Interested Party Reference Number: 20039546

Deadline 5 Submission:

**Application by Tritax Symmetry (Hinckley) Limited for an
Order Granting Development Consent for the Hinckley
National Rail Freight Interchange**

(ref. TR050007)

Written Statement of Oral Case ISH6 [Appendix C – Plan for A47 link road footway/cycleway design]

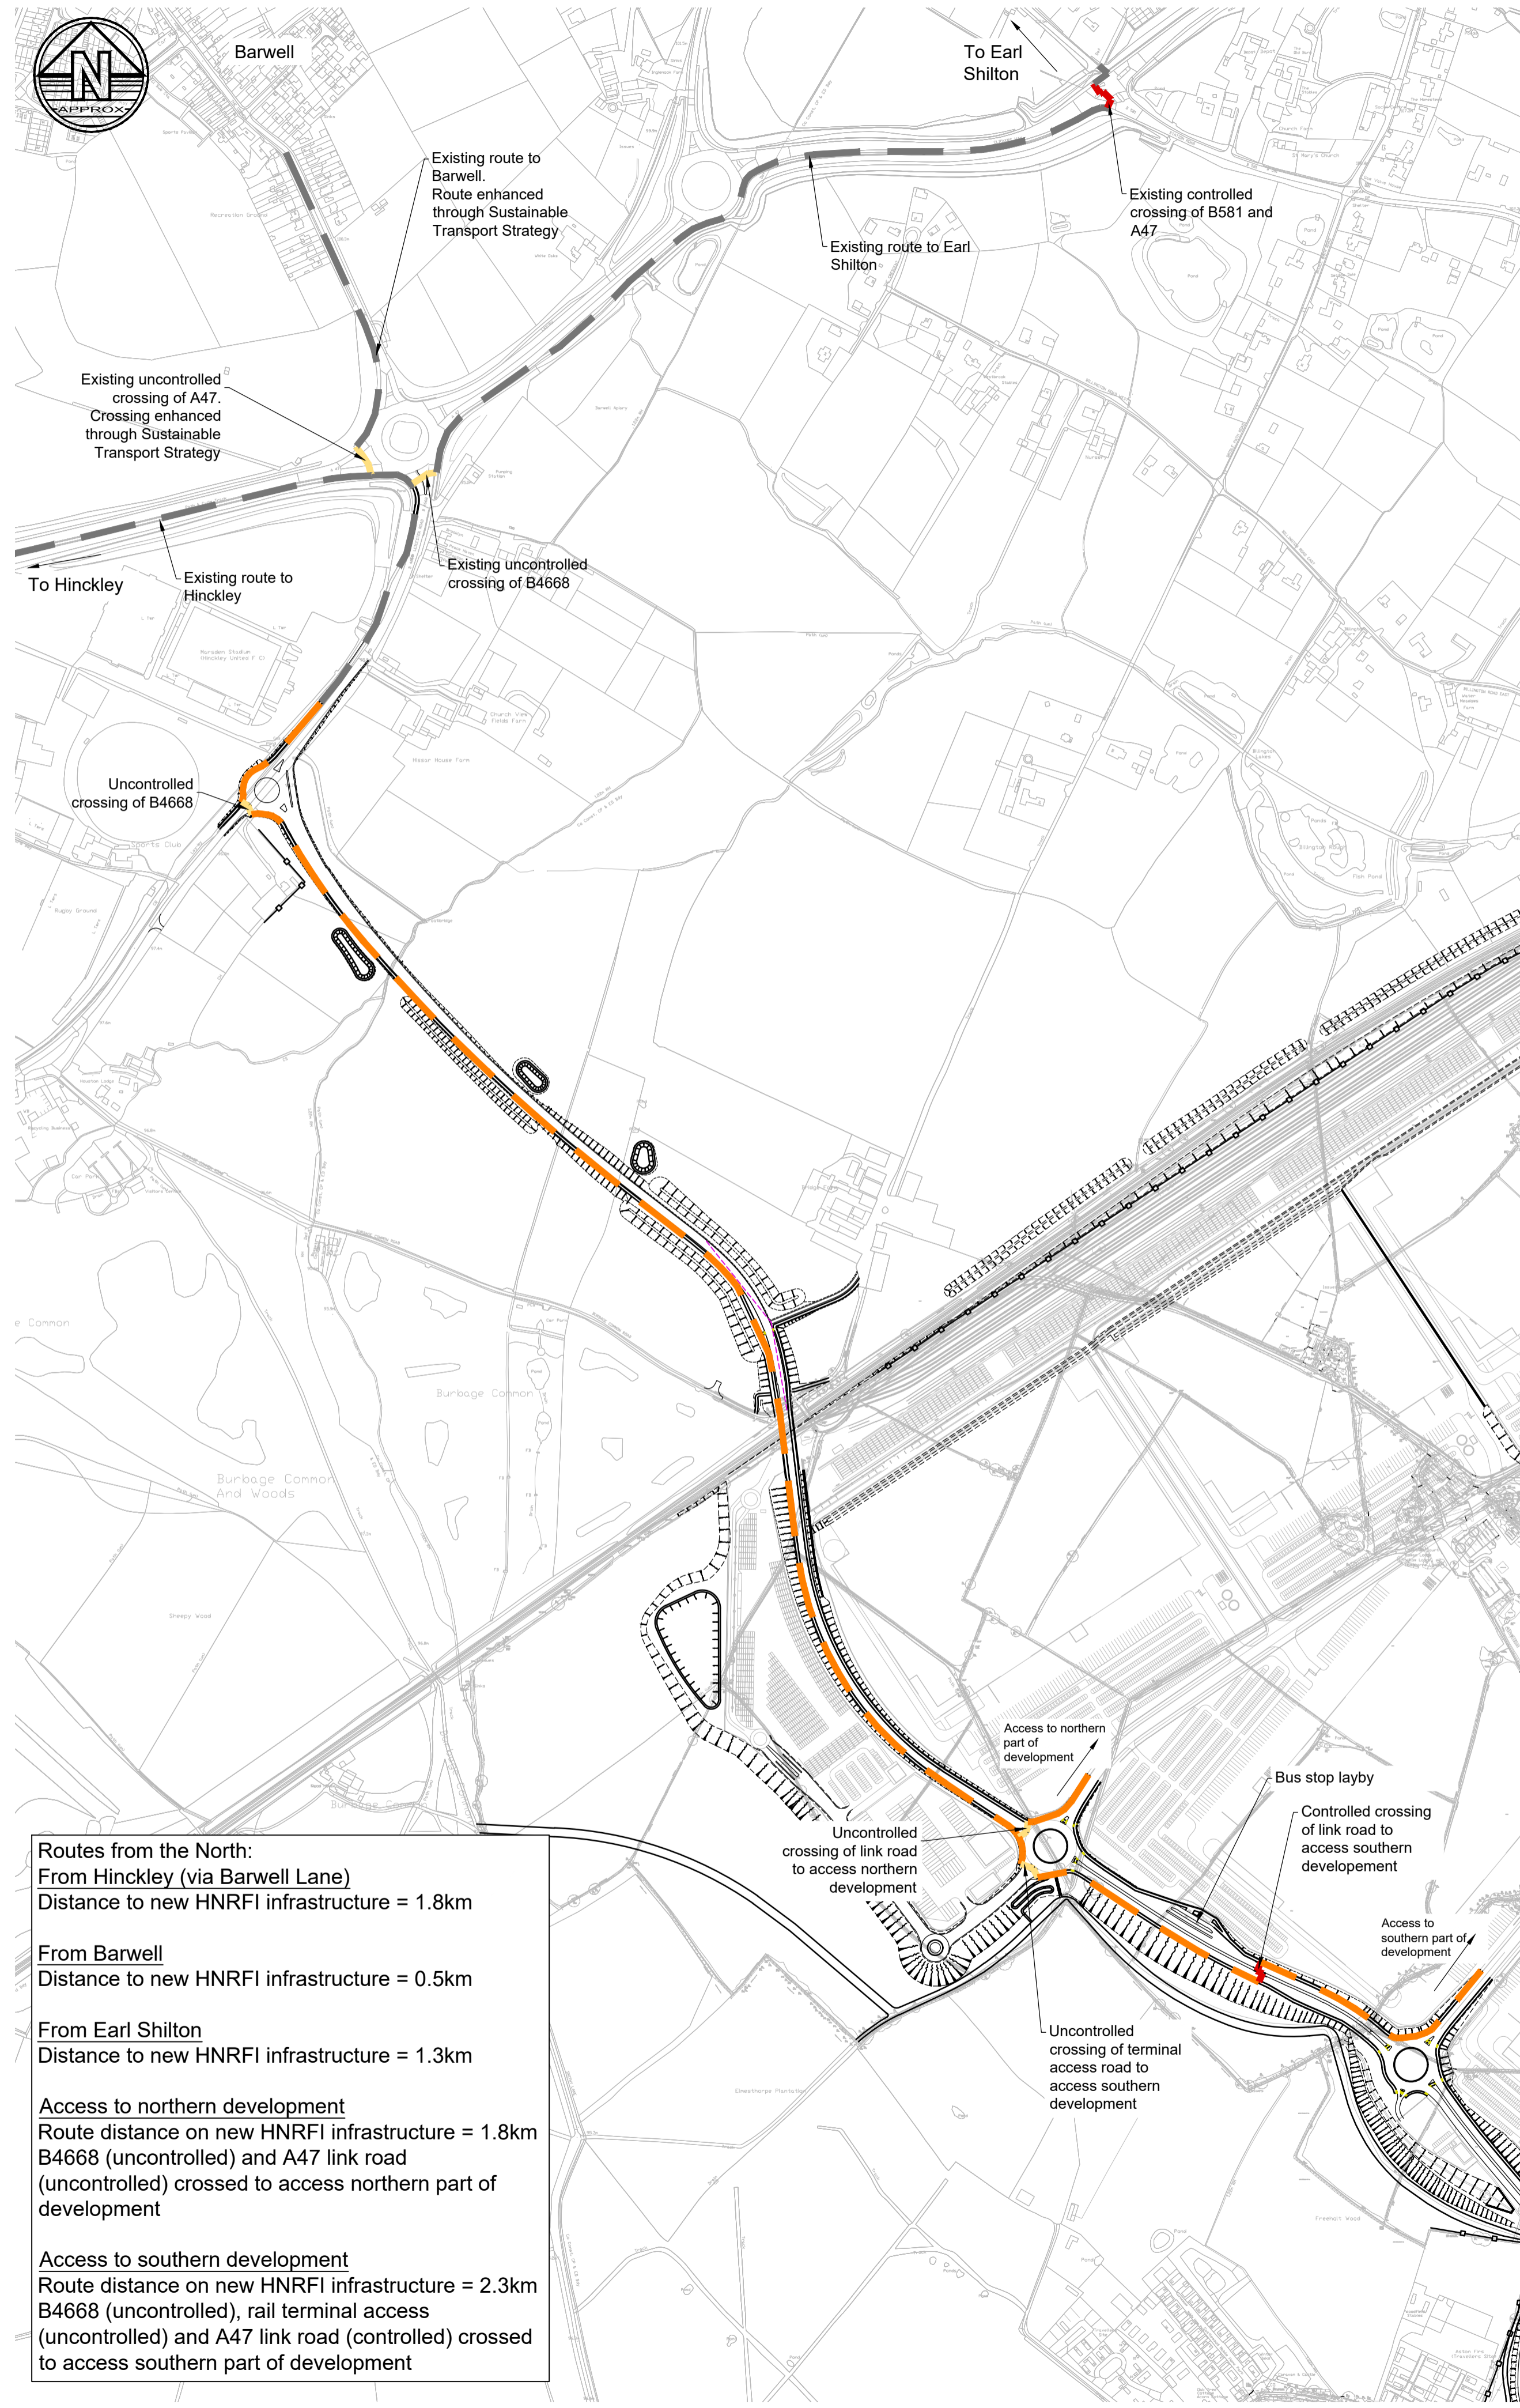
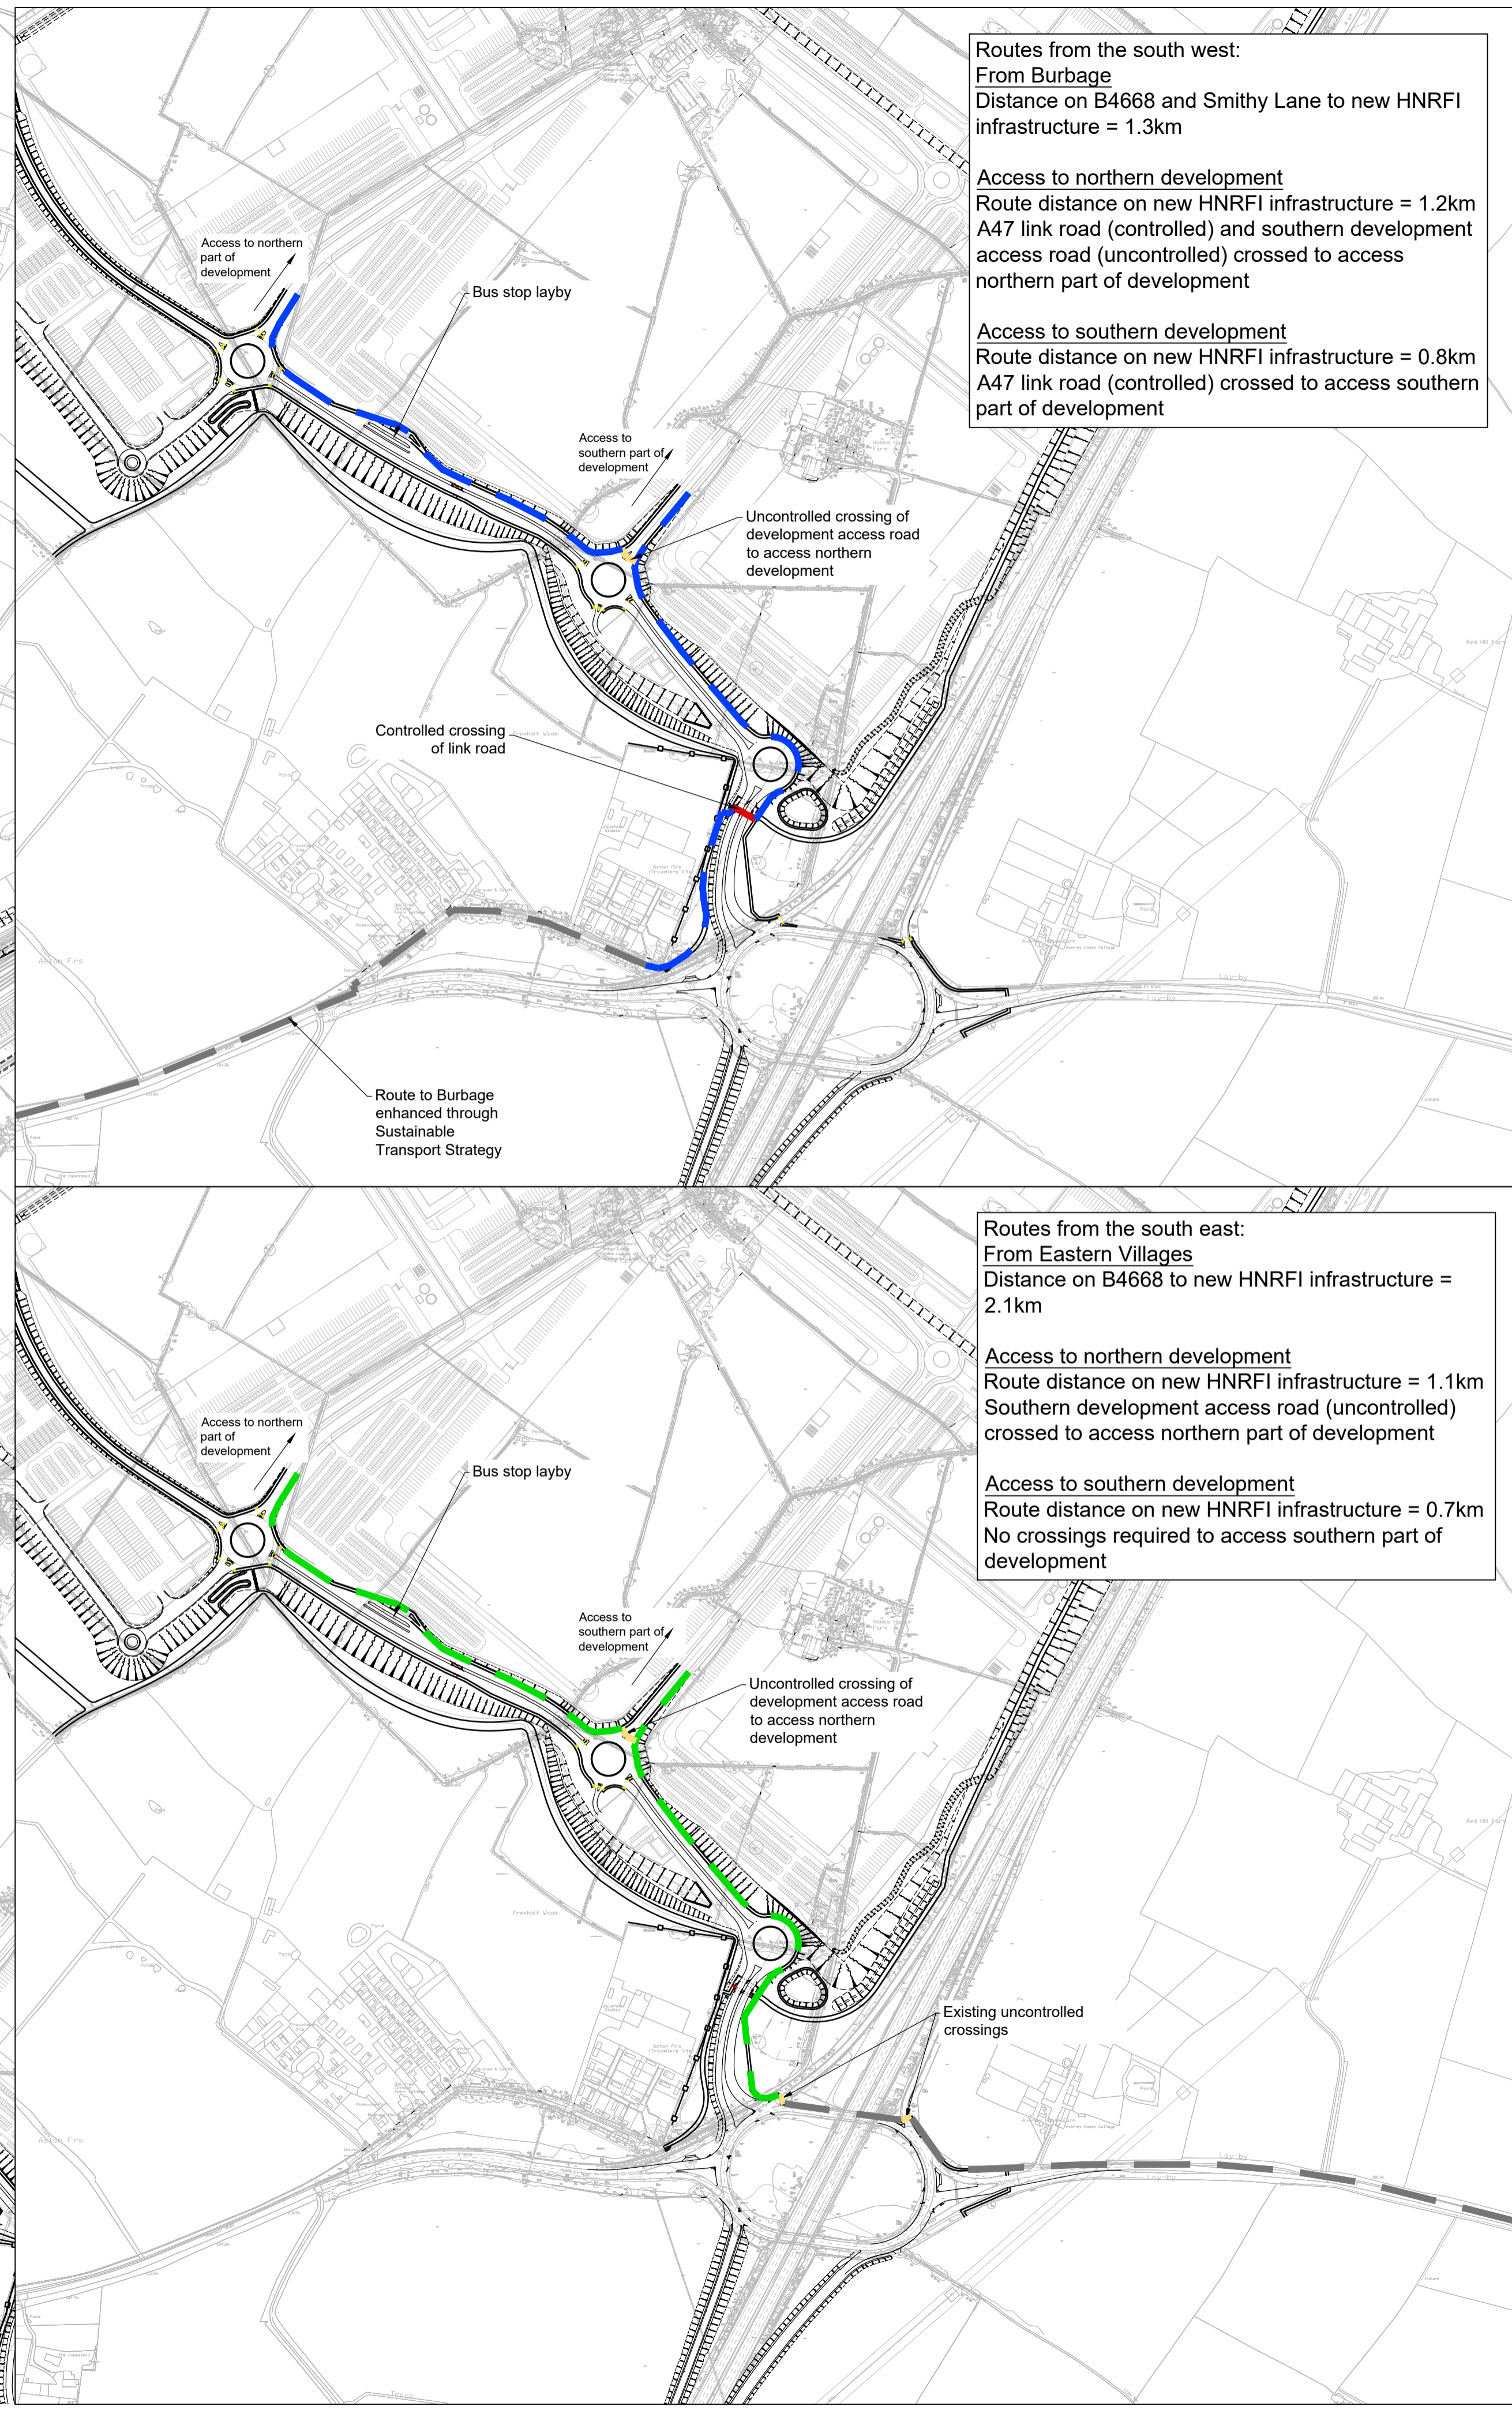
2. The provision of shared use facilities on the new link road is welcome, but they appear to fall short of the direct and continuous requirements in LTN1/20, as in one case the facilities appear to end without a connection (sheet 4) and the users of this path have to cross the road in 2 locations to continue in a north/south direction (sheets 1 and 4) – see highway plans below. **Consideration should be given to a continuous cycle route in a north/south direction adjacent to the link road.**
